Phone: 0300 123 6780
Email: lhscustomerservice@lancashire.gov.uk
Your ref:
Our ref: LHS/CS/3/2016/0296
Date: 28th April 2016

Proposal:	Erection of two detached dwellings
Location:	8 Hammond Drive Read BB12 7RE
Grid Ref:	376103 - 434841

PROPOSED SITE PLAN
1:200 SCALE

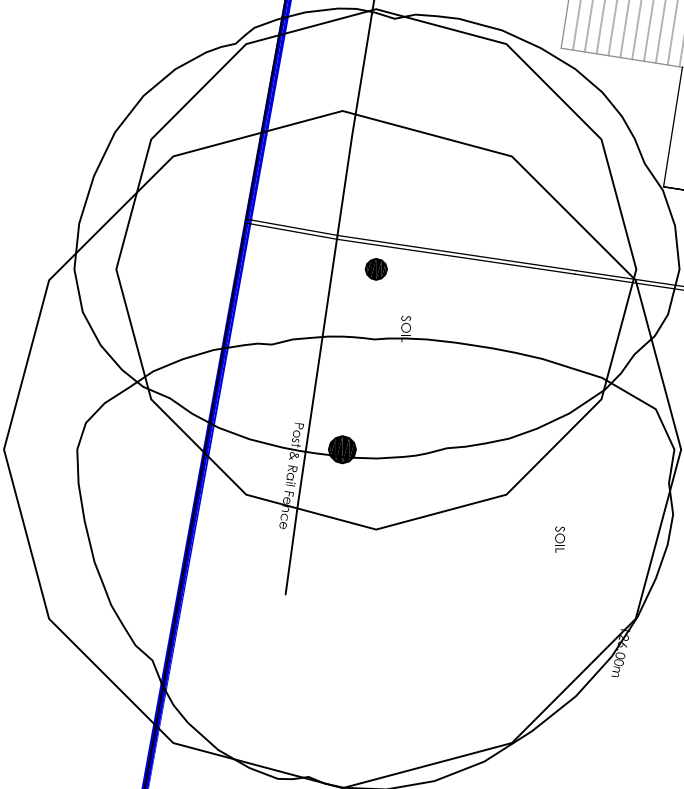
The Highway Development Control Section does not have any objections in principle to the proposed relocated dwelling and the provision of 1 new dwelling providing the gate is relocated and the recommended number of off-road car parking is provided.

Based on the car parking recommendations in the Joint Lancashire Structure Plan and the Ribble Valley Parking Standards, the Highway Development Control Section is of the opinion that the applicant should provide three off road parking spaces for dwellings with four or more bedrooms.

Any gateposts erected at the access should be positioned 5.5m behind the nearside edge of the existing edge of carriageway. The gates shall open away from the highway

1. Before the access is used for vehicular purposes, any gateposts erected at the access shall be positioned 5.5m behind the nearside edge of the existing edge of carriageway. The gates shall open away from the highway. Reason: To permit vehicles to pull clear of the carriageway when entering the site to open and close the gate.
2. A car park and manoeuvring scheme to be approved by the Local Planning Authority and the car parking spaces and manoeuvring areas marked out in accordance with the approved plan, before the use of the premises hereby permitted becomes operative and permanently maintained thereafter. Reason: To allow for the effective use of the parking areas.
